Rezoning Transportation Analysis

Petition Number: 2022-224

Date	Description
4-26-23	First Review (IW)

RZP # 2022-224  
OFFICE AND RETAIL  
CENTRAL AVENUE AND MORNINGSIDE DRIVE  
2609 CENTRAL AVENUE

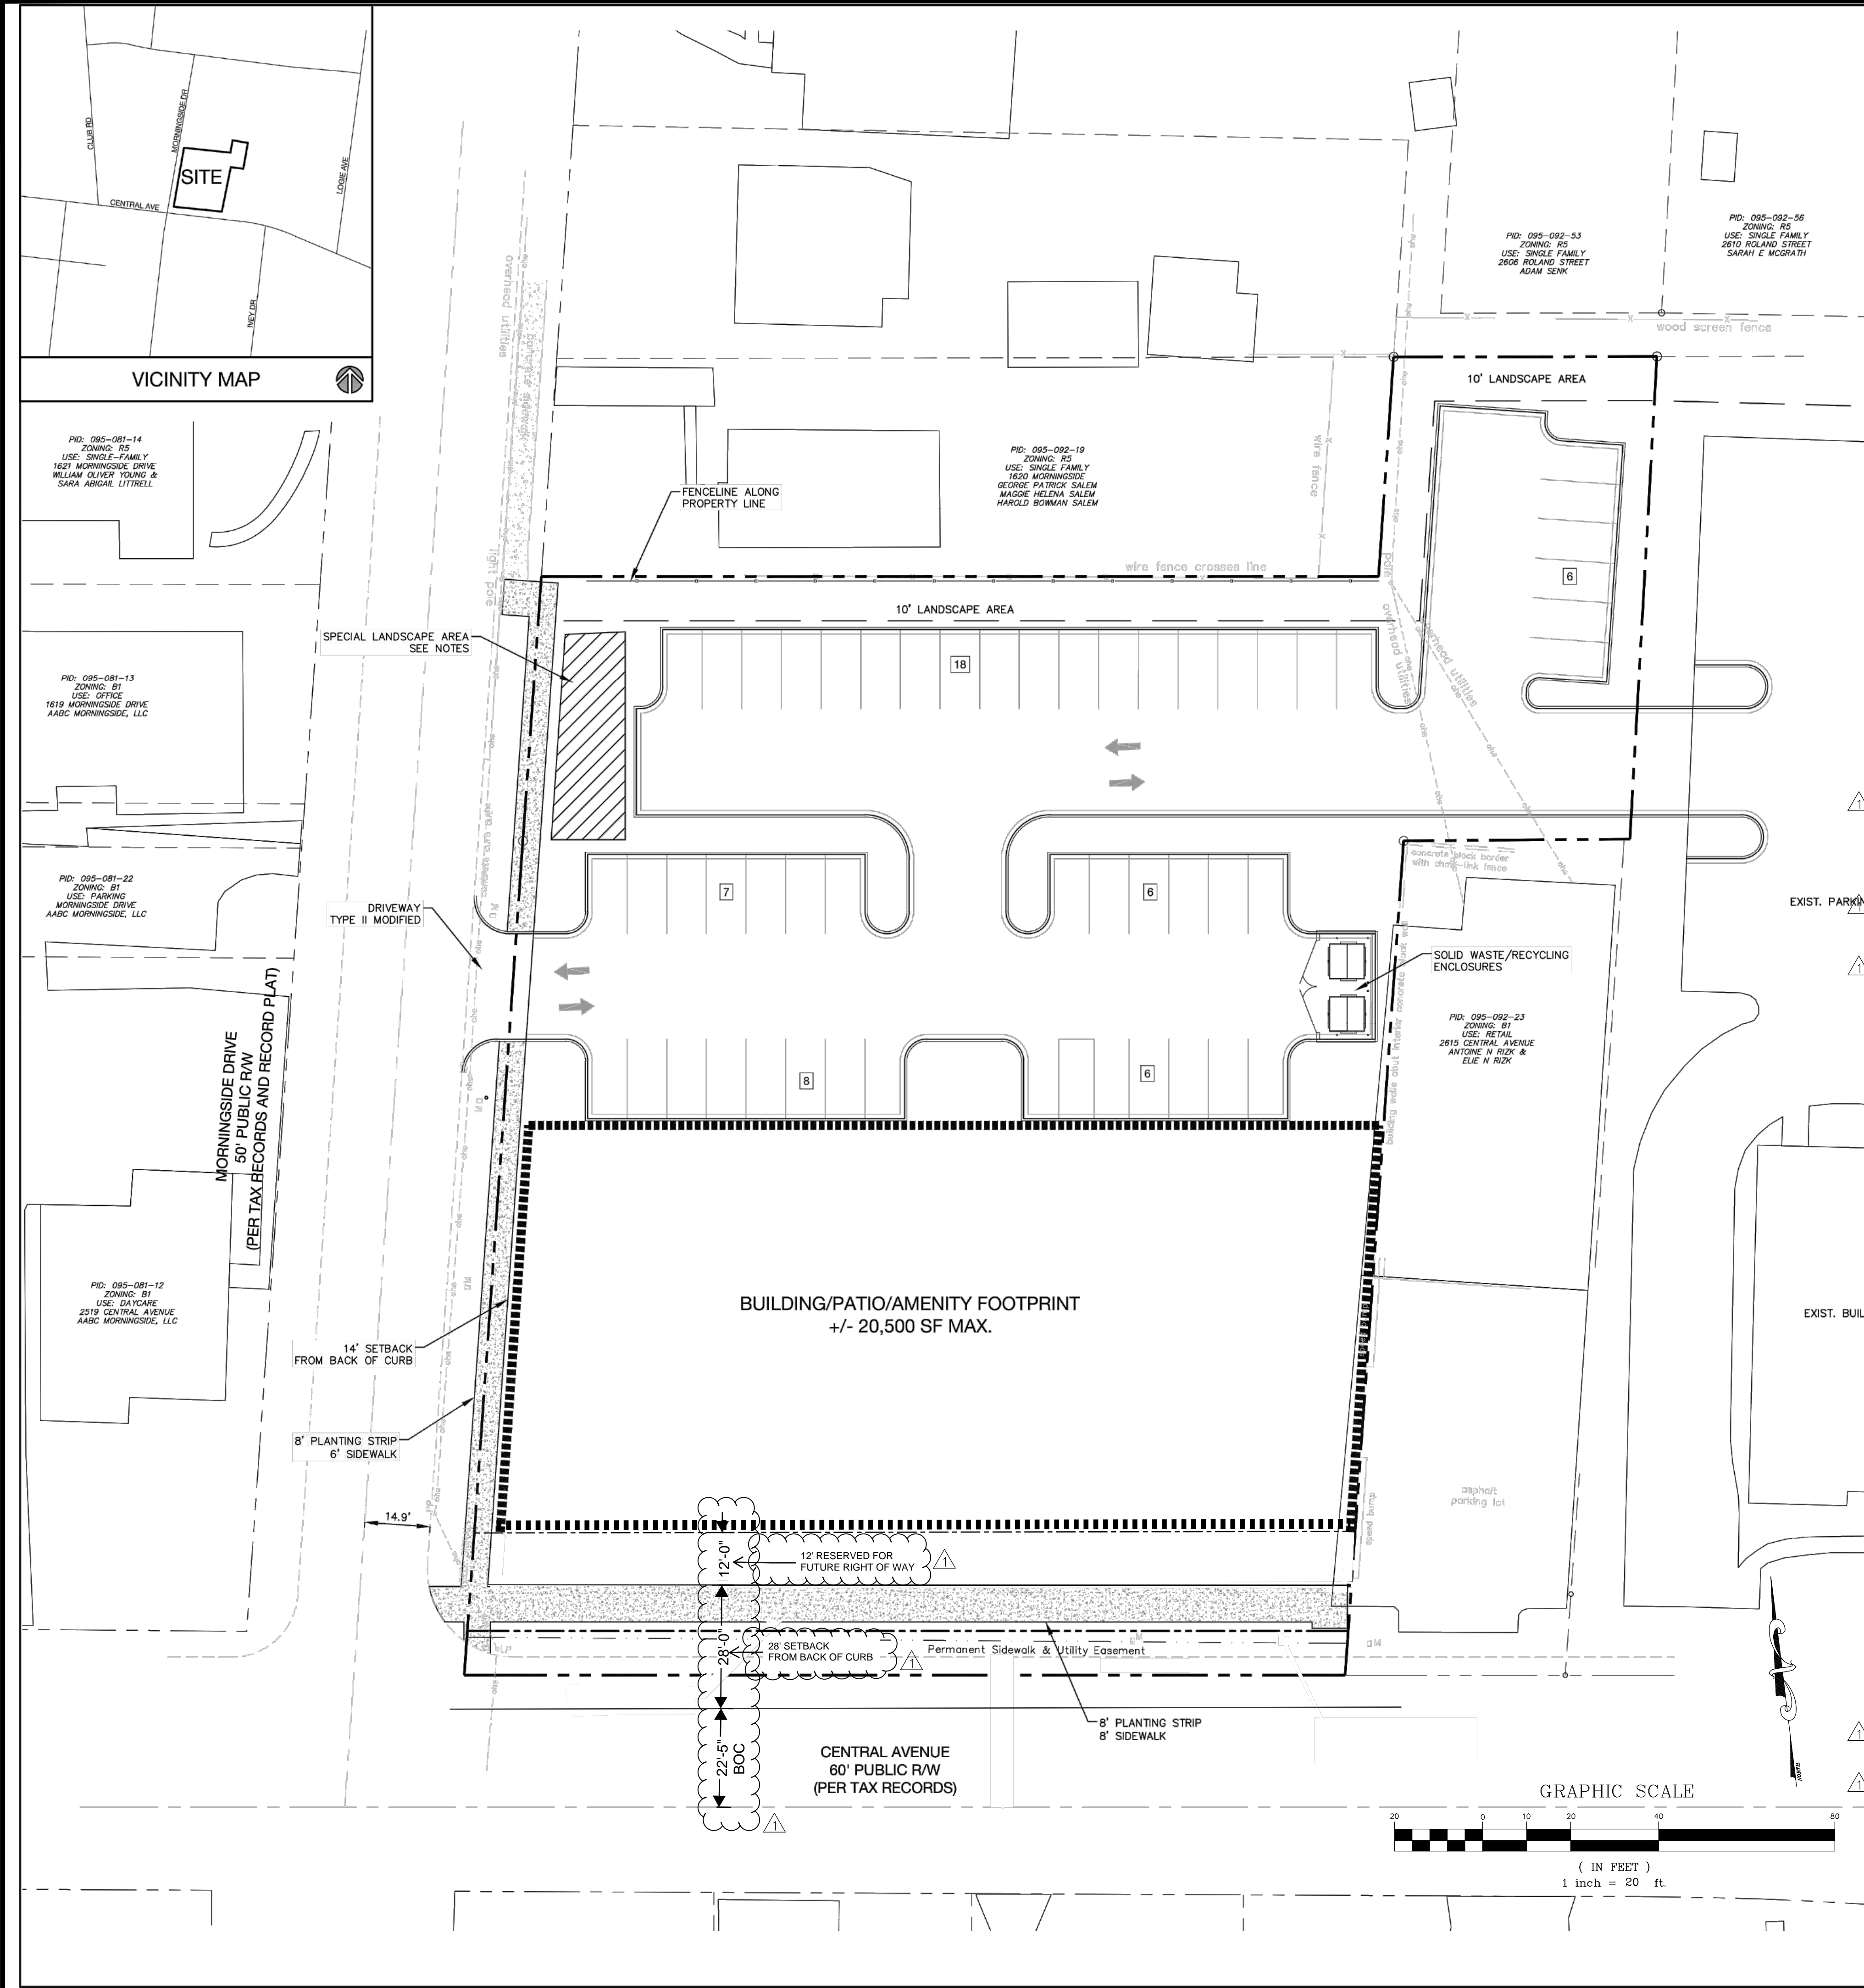
- a. **Central Avenue:** Location of curb and gutter to be moved to 32.5 feet from roadway centerline to accommodate the Charlotte Streets Map with a roadway typical section of 4 Avenue with Buffered/Separated Bike Lanes.
- b. **Morningside Drive:** The future location of curb and gutter is in its existing location.

Label and dimension the curb and gutter from the centerline for each road on the site plan.

- 3. Revise site plan and conditional note(s) to commit to dedicate 50.5 feet of right-of-way from the Central Avenue road centerline. The site plan shall label and dimension the right-of-way from the road centerline.

5. Revise site plan to add density information for site.
6. Add a conditional note specifying "the Petitioner shall dedicate and convey in fee simple all rights-of-way to the City before the site's first building certificate of occupancy is issued. CDOT requests rights-of-way set at 2' behind back of sidewalk where feasible."
